THURROCK FLEXIBLE GENERATION PLANT - DEADLINE 2 - WRITTEN REPRESENTATION

As an interested party to the examination of the Thurrock Flexible Generation Plant DCO (EN010092) Highways England (20025438) make the following Written Representation (following our Relevant Representation ([RR-016](#))). In addition to this Written Representation, we have prepared a response to the Examining Authority's questions (Attachment B).

Thurrock Flexible Generation Plant Lower Thames Crossing Comparison Index Sheet

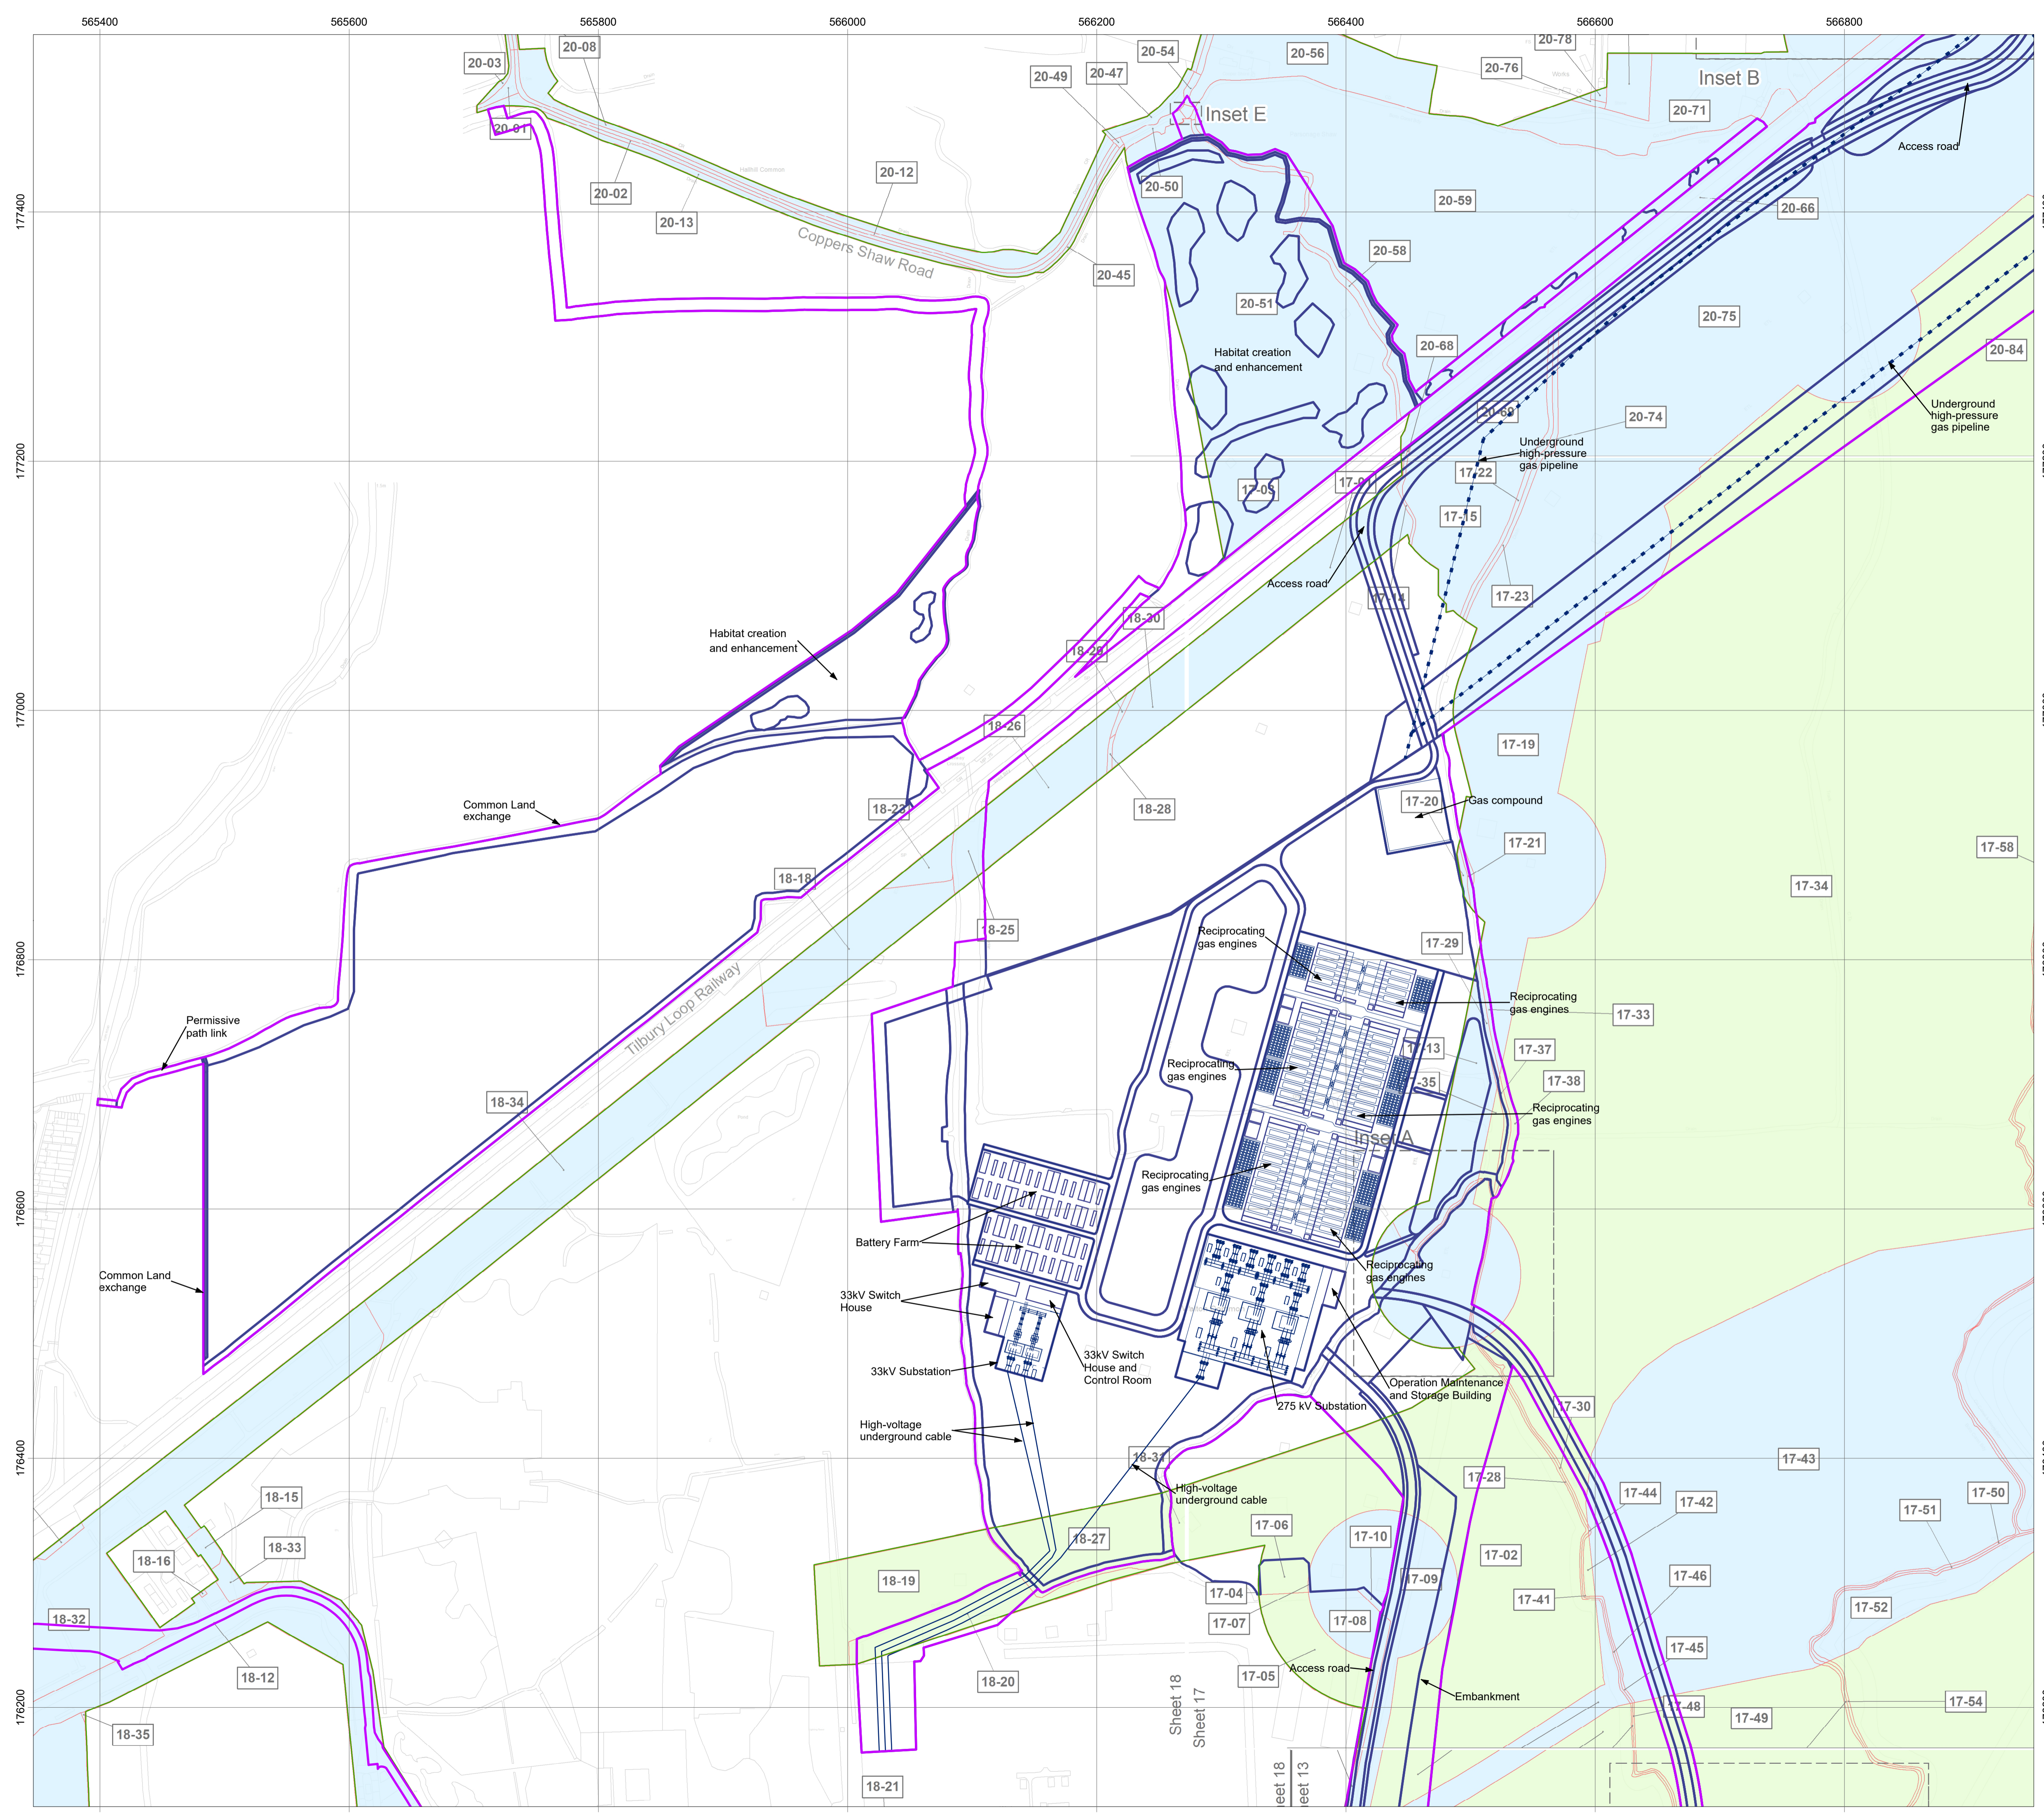
Highways England have provided Thurrock Power Ltd (the Applicant) with a copy of their October 2020 withdrawn application for reference. The separate figure(s) provided by the Applicant in response to EXQ1.17.4 shows the overlay of the two project's Order Limits.

The Applicant has submitted a plan in response to ExQ1.17.4 showing the overlay of the Thurrock Flexible Generation Plant and Lower Thames Crossing Project's Order Limits on behalf of both themselves and Highways England.
